Mrs Rachael Warne
3
Woodside
Barnham
PO22 0HZ

Please ask for: Ms Iqraa Malik
Email: iqraa.malik@terraquest.co.uk
Telephone: 01212341390
Our Ref: BN/74/20/HH
Your Ref:
Date: 15th July 2020

Application for Planning Permission for Works or Extension to a Dwelling

Development: Change of use of some of our land from public amenity land to private garden, and erect new 1.8m wooden fence with concrete posts
Location: 3 Woodside Barnham PO22 0HZ

1:50 elevation plan

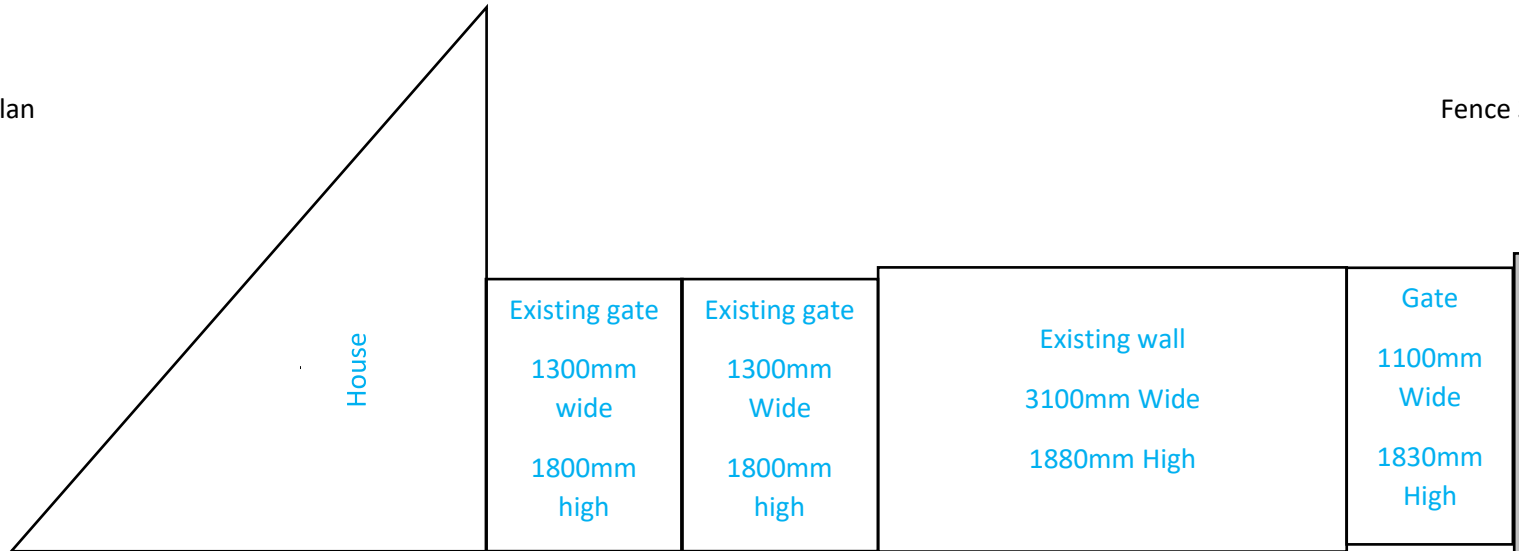
Elevations

Please submit a copy of clearly labelled existing and proposed elevations at a scale of 1:50 or 1:100. Further details can be found in the Validation Requirements List.

BLOCK PLAN

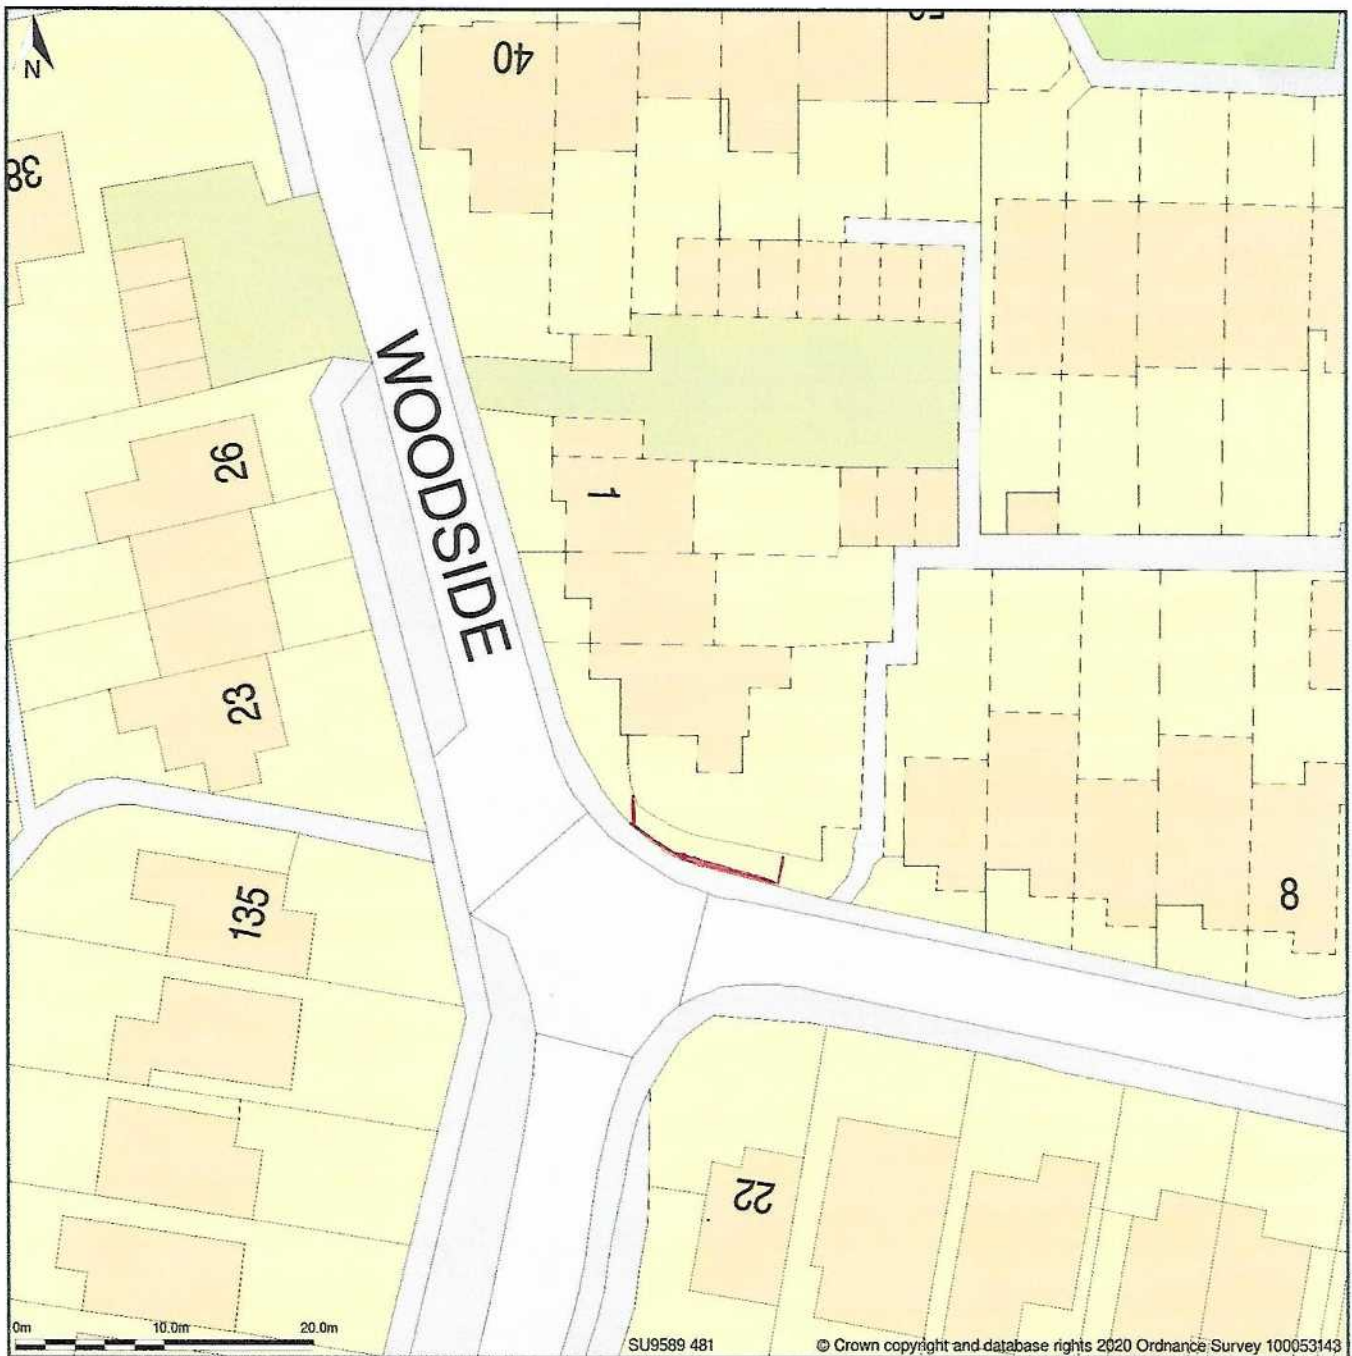
Block Plan

Please amend the scale bar on your Block Plan as this doesn't measure to scale. You are required to have dimensions from the proposed extension to all site boundaries. Please amend. Further details of what must be included on the plan can be found in the Validation Requirements List.
